## OFFICER'S REPORT

APPLICATION NUMBER: S6/2003/1311/FP

LOCATION: Wyndham Cottage, Camfield Place, Essendon

PROPOSAL: Erection of two storey side extension and rear conservatory

MR.

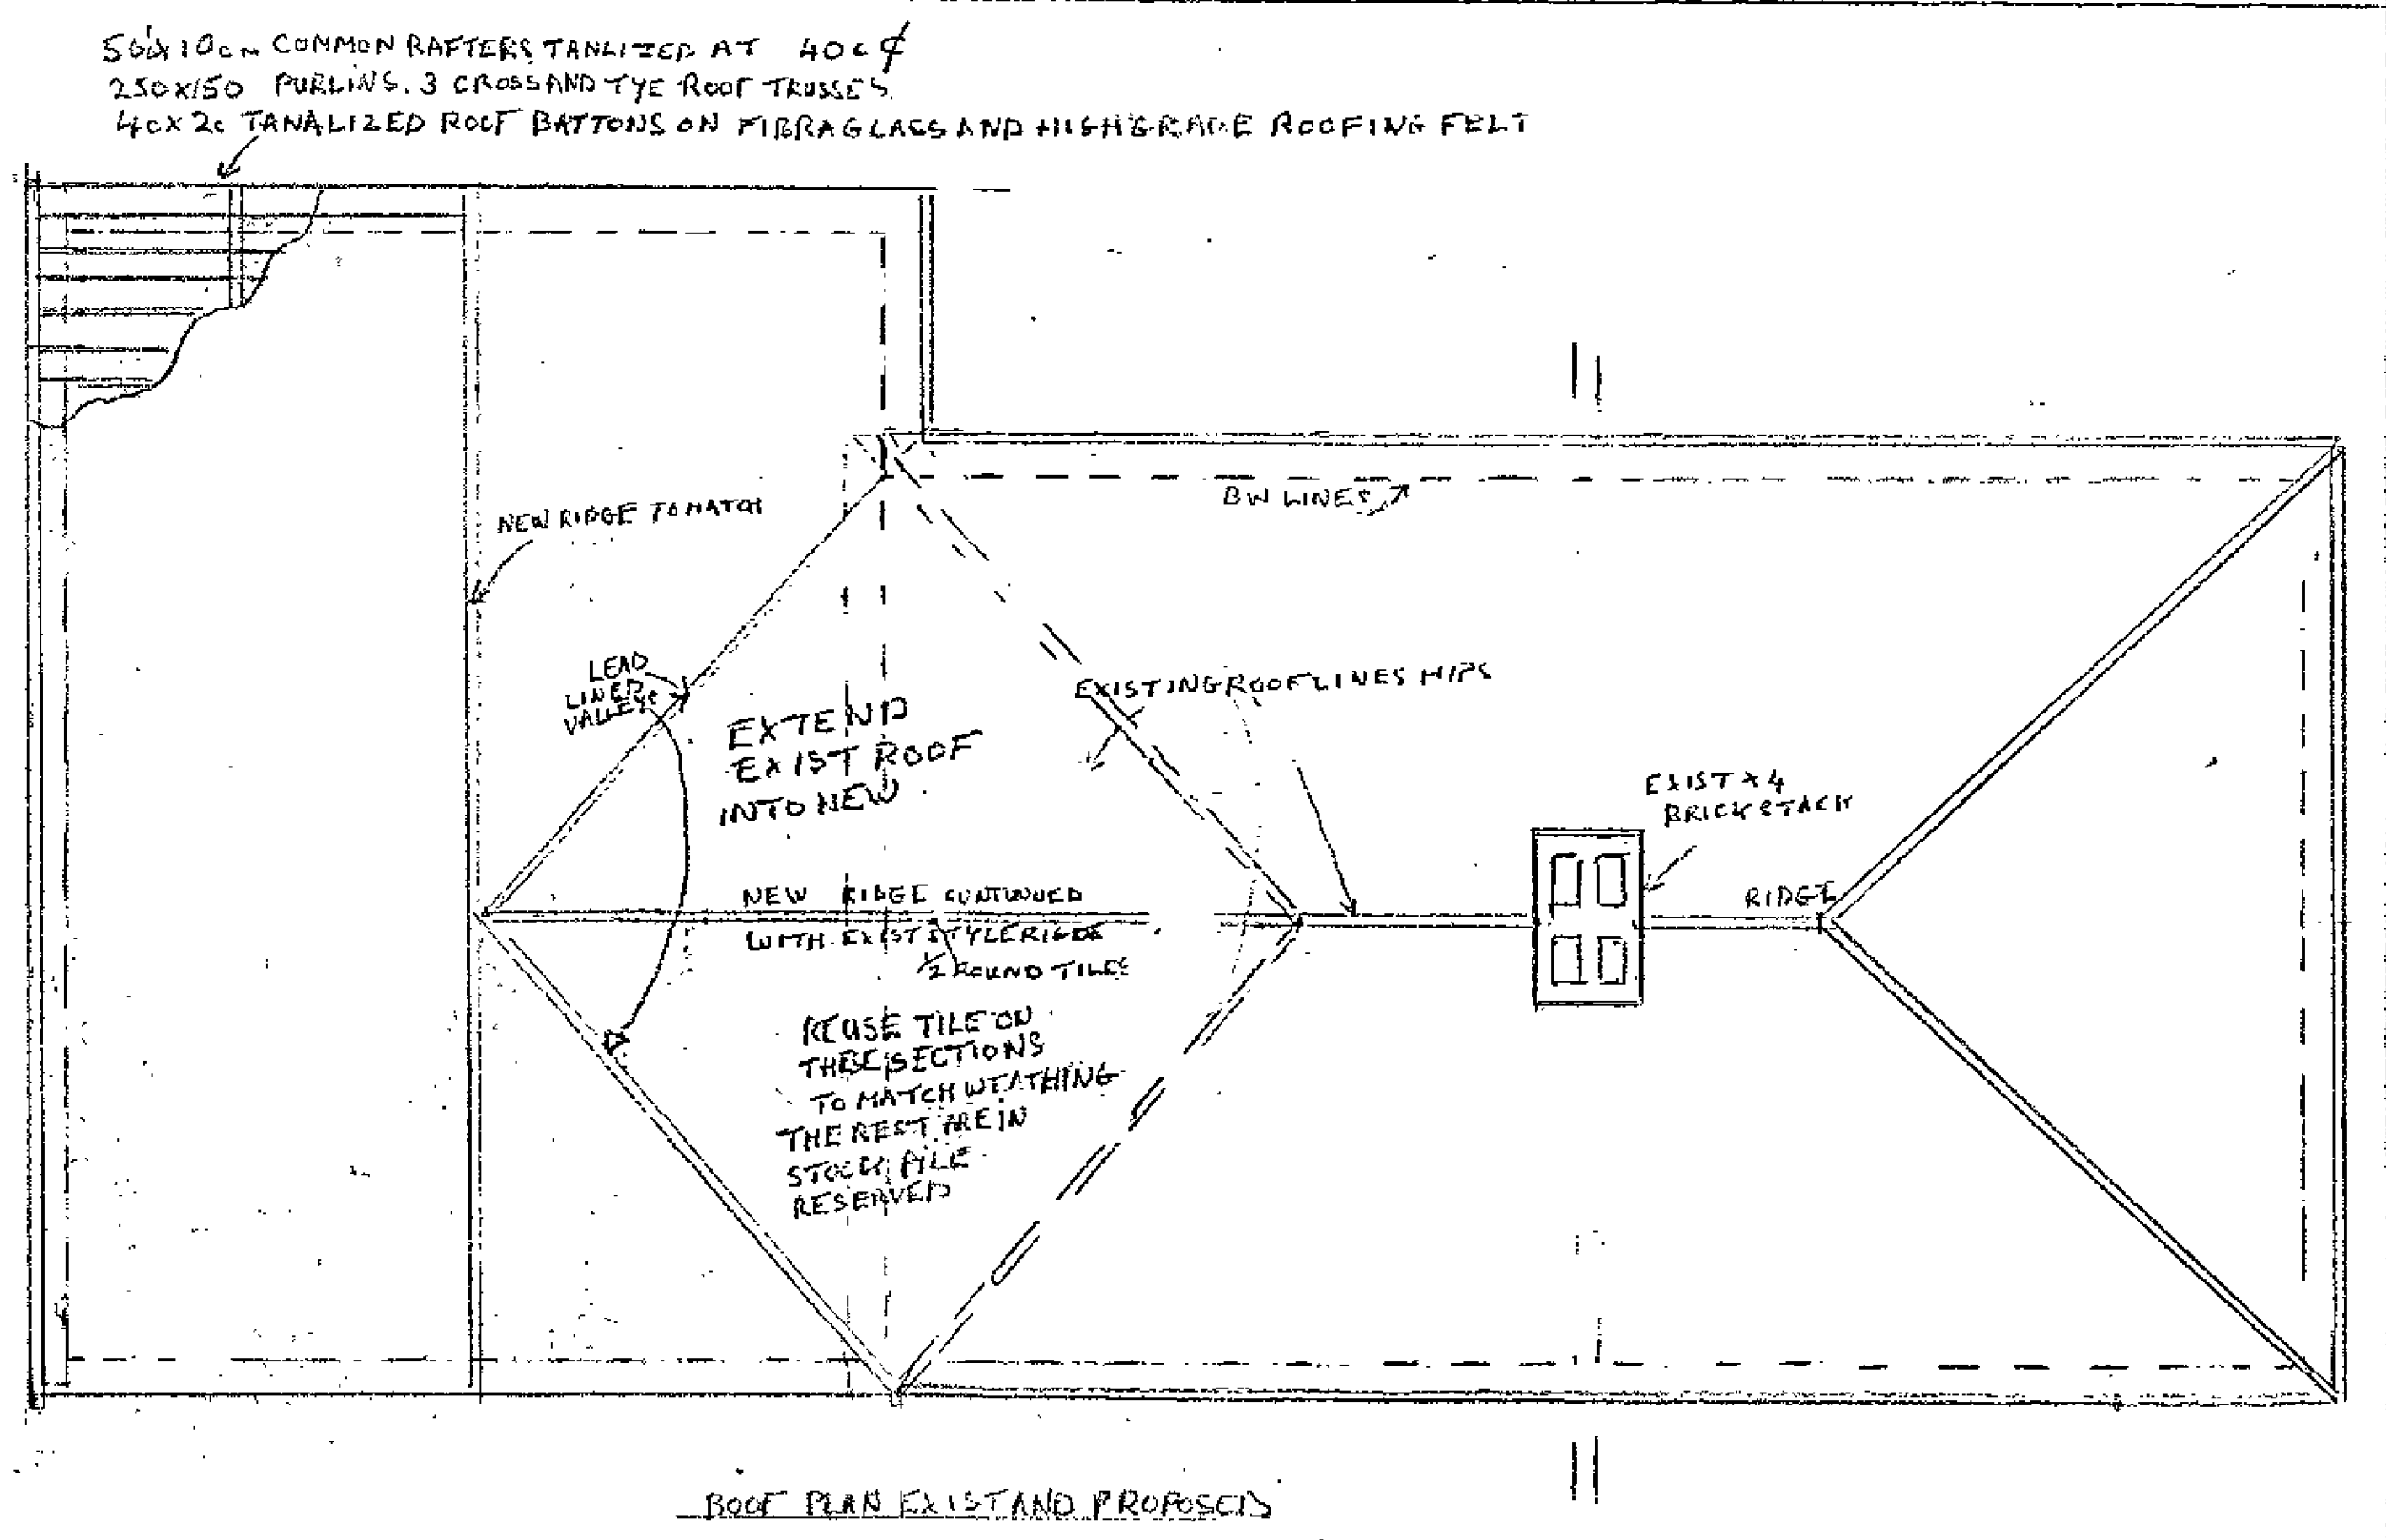
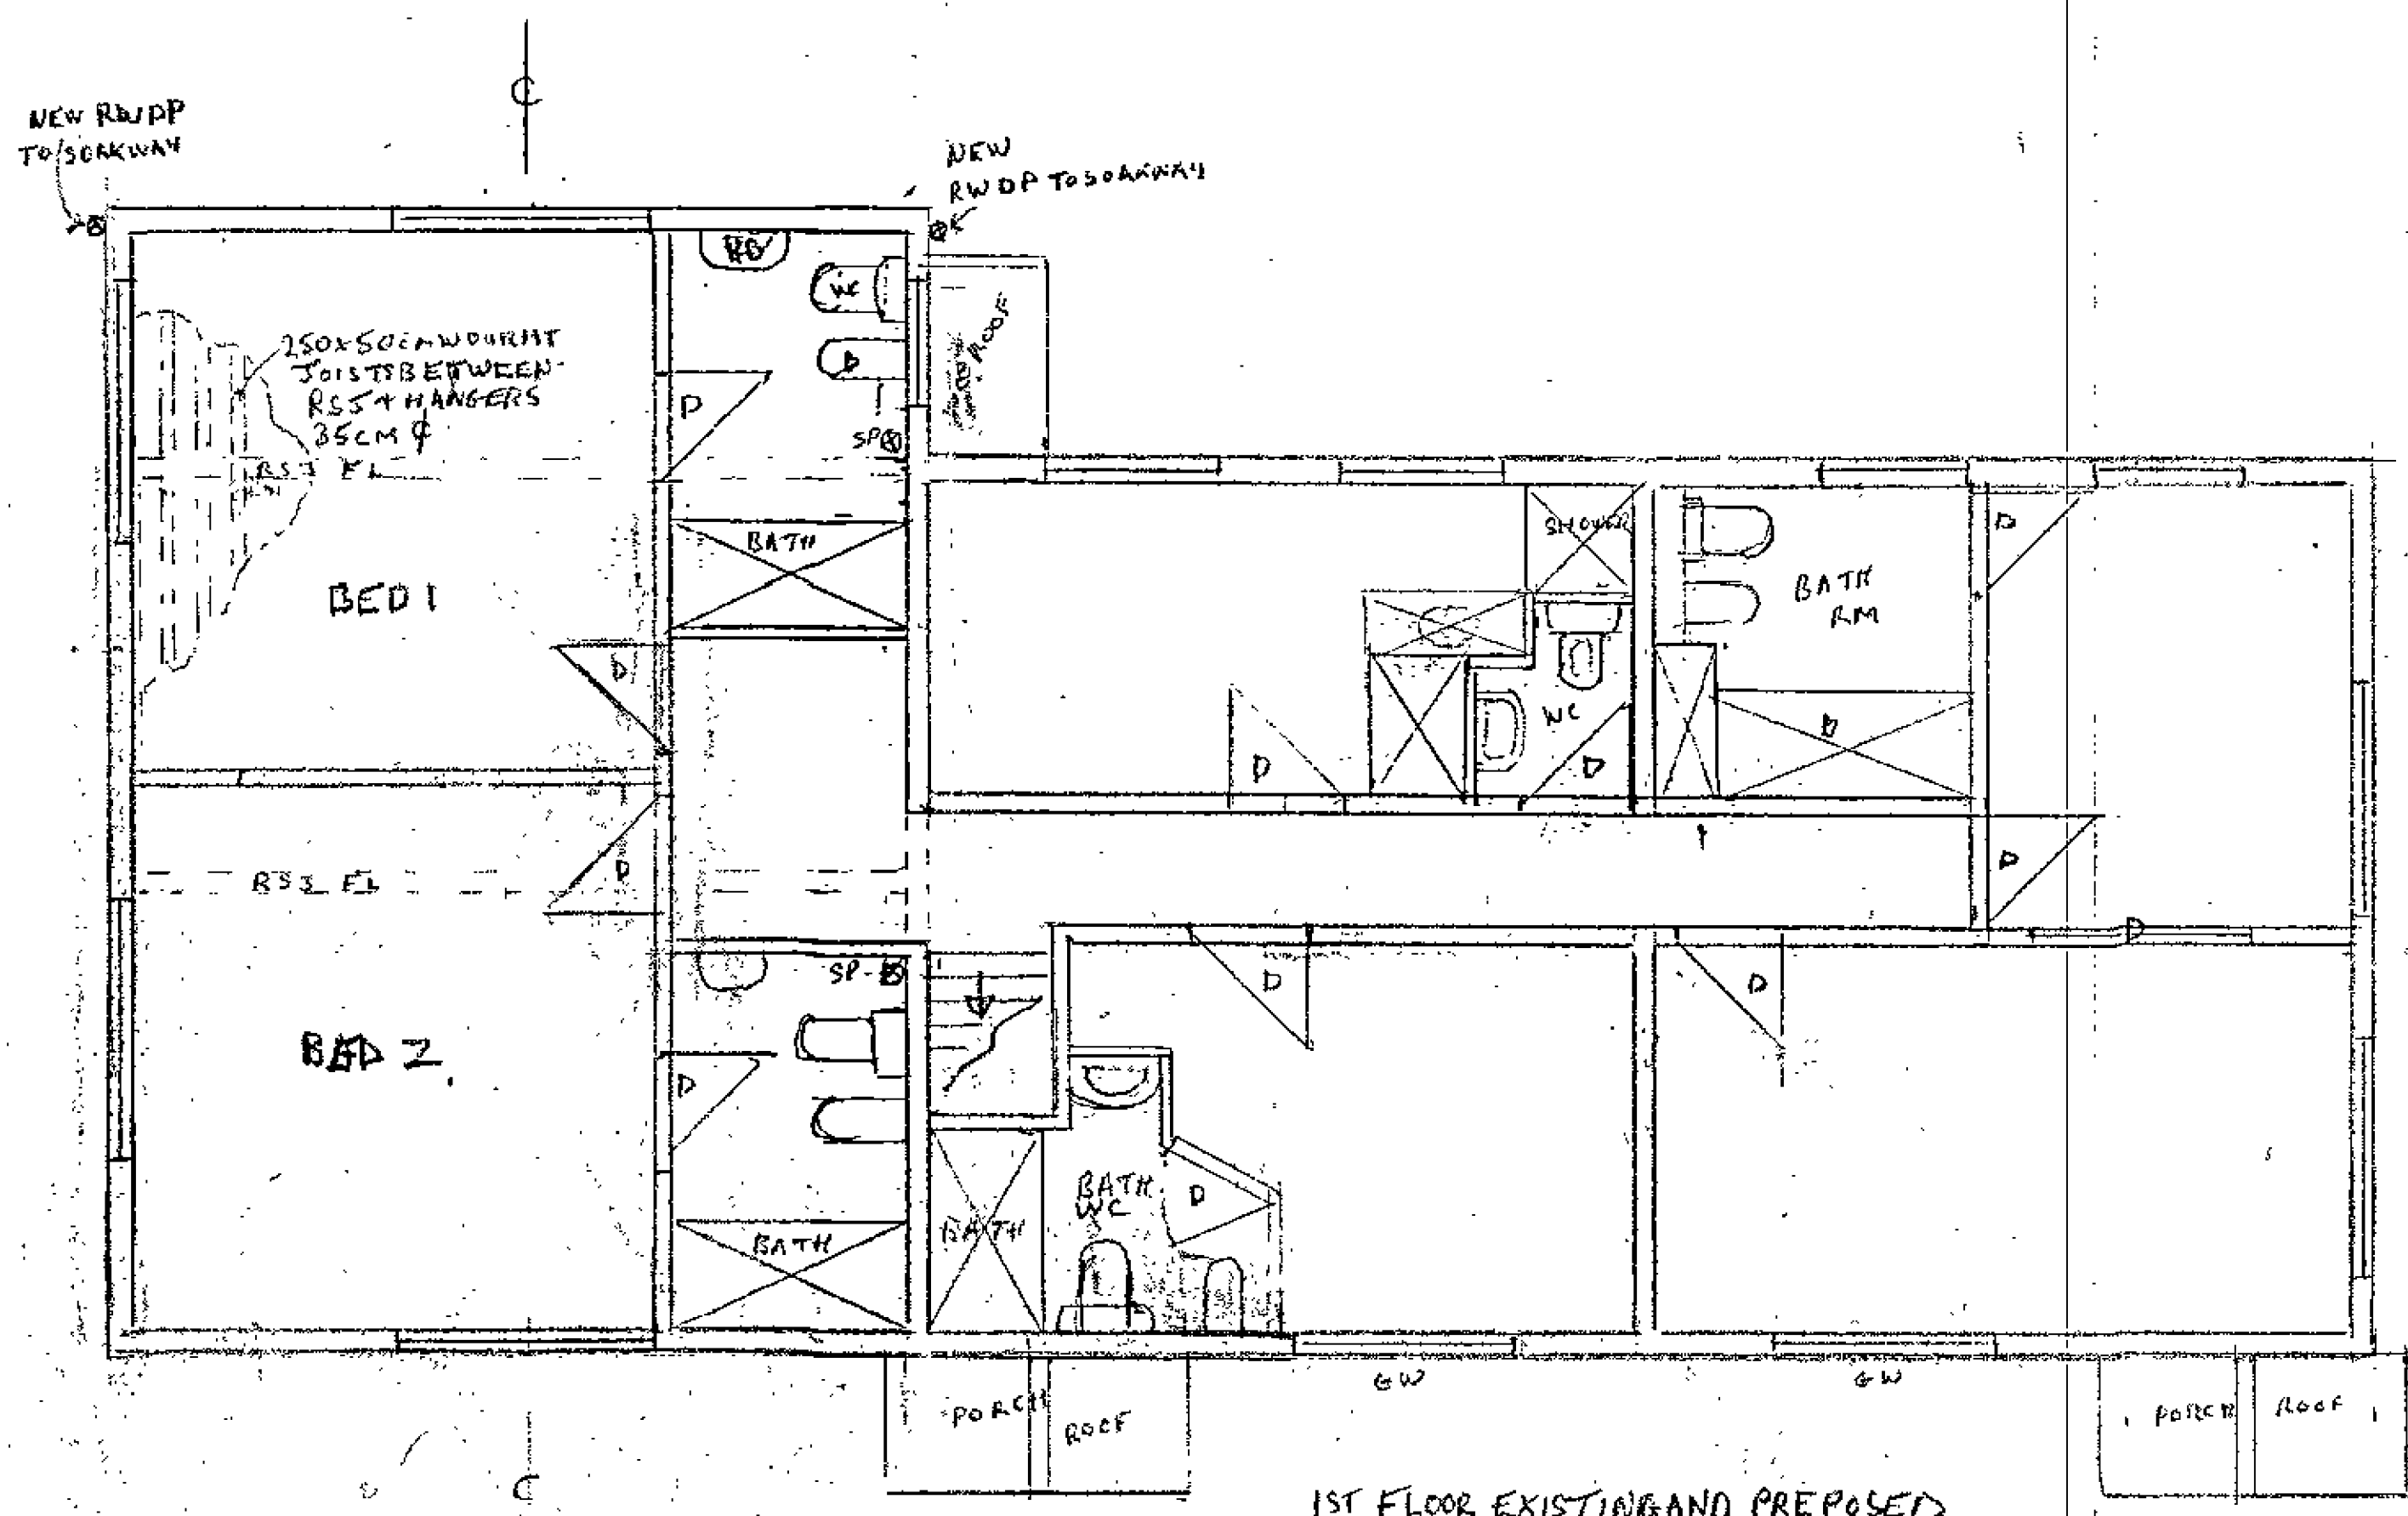
In terms of the Council's Residential Criteria, the application is also not acceptable. The extension would not be subordinate to the original dwelling and does not reflect the design or character of the house through the introduction of a gabled roof. The extension would also visually unbalance the appearance of the dwelling. Due to its isolated location and position away from the road the extension will accord with all other aspects of this policy.
